**RE: STATE SIGNIFICANT DEVELOPMENT APPLICATION (SSD 10422) FOR PROPOSED BRICKWORKS PLANT**

**PROPERTY AT: 416 & 524 BERRIMA ROAD, MOSS VALE (LOT 1 DP 785111 & LOT 1 DP 414246)**

## **State Significant Development Application – SSD 10422**

Figure 1: Extent of Exceedance of the 24-hour average HF Concentrations on Impact Area 2 (Represented by the Solid Orange Coloured Area)

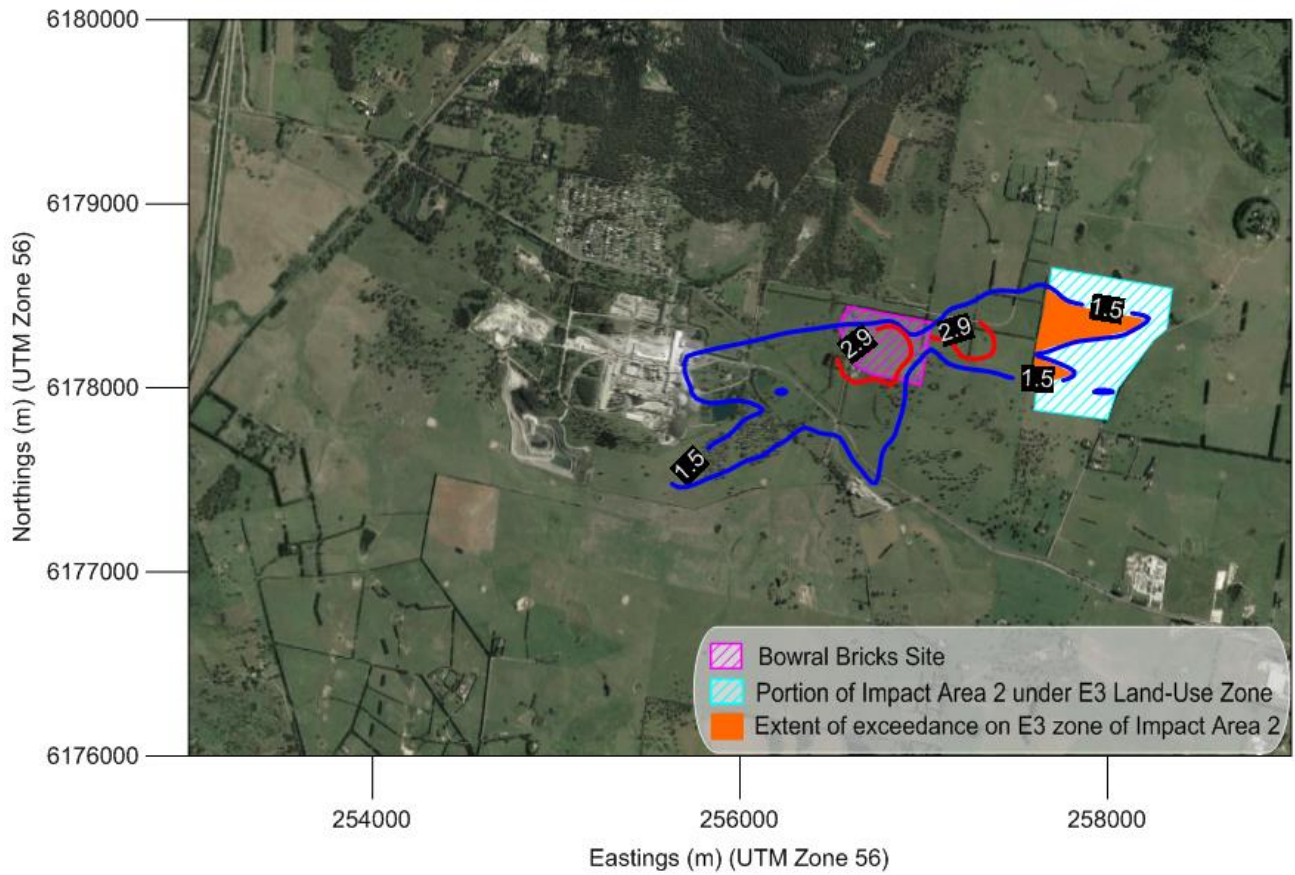
*Incremental and cumulative HF ground level concentration isopleths have been overlaid on the Wingecarribee Local Environmental Plan 2010 to determine the extent of the predicted HF impacts. When the sensitive land use assessment criterion of 1.5 µg/m<sup>3</sup> (24-hour) is applied, the results of the dispersion modelling show predicted impacts above the EPA's impact assessment criteria in the land zoned E3 to the North West of the proposed facility. As such, there is potential that future specialised land use potential in this area may be affected, including vegetation sensitive to fluoride, such as grape vines and stone fruits.*

*The EPA recommends the proponent be required to provide supporting evidence of the information considered in Airlabs survey of the potential for sensitive lands surrounding the proposed project site.*

comprising IN1 General Industrial and E3 Environmental Management. Across the E3 Environmental Management zoned, the predicted 24-hour concentrations (refer to Figure 1 within **Appendix 2**) exceed the sensitive land use assessment criteria for an area which is limited to a maximum area of approximately 10 hectares (ha) in size. Across the remaining area of the E3 Environmental Management zone, the predicted concentrations comply with the sensitive land use assessment criteria.
